# PLANNING AMENDMENT

| <b>SITE ADDRESS DETAILS</b><br>14 Forge Crescent, Pinchbeck, Spalding, Lincs, PE11 3TN                                                  |                                                                                                                                  |
| <b>CURRENT APPLICATION NO:</b><br>This amendment cannot be considered unless the relevant reference is stated.                          | H14-0224-26                                                                                                                      |

| <b>FULL DESCRIPTION OF DEVELOPMENT OF CURRENT APPLICATION THAT THIS AMENDMENT RELATES TO</b>                                                                                             | Proposed first floor side extension and alterations |          |

FRONT ELEVATION

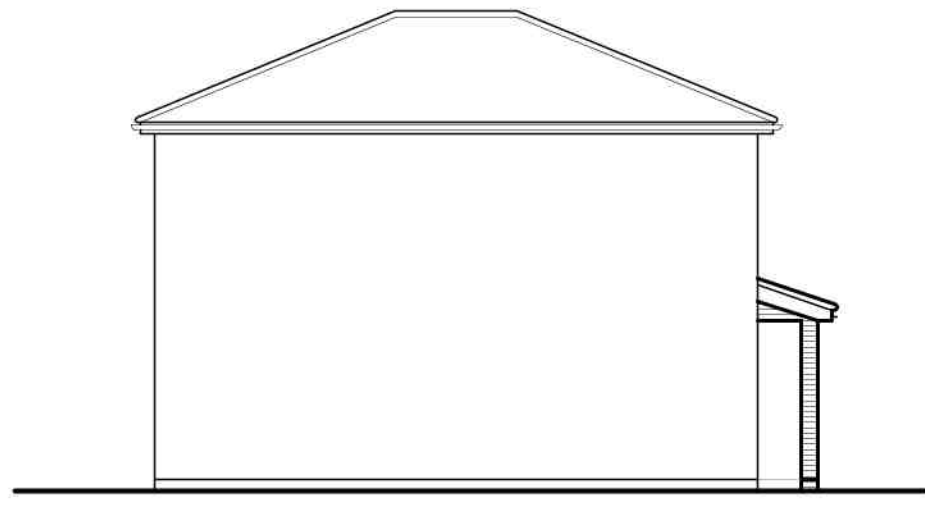
| State details of amendments proposed. (Give a full detailed list of the changes, and also mark these clearly on the accompanying plans. Only the changes listed here will be considered) | Amended Roof and ridge Height                       |          |
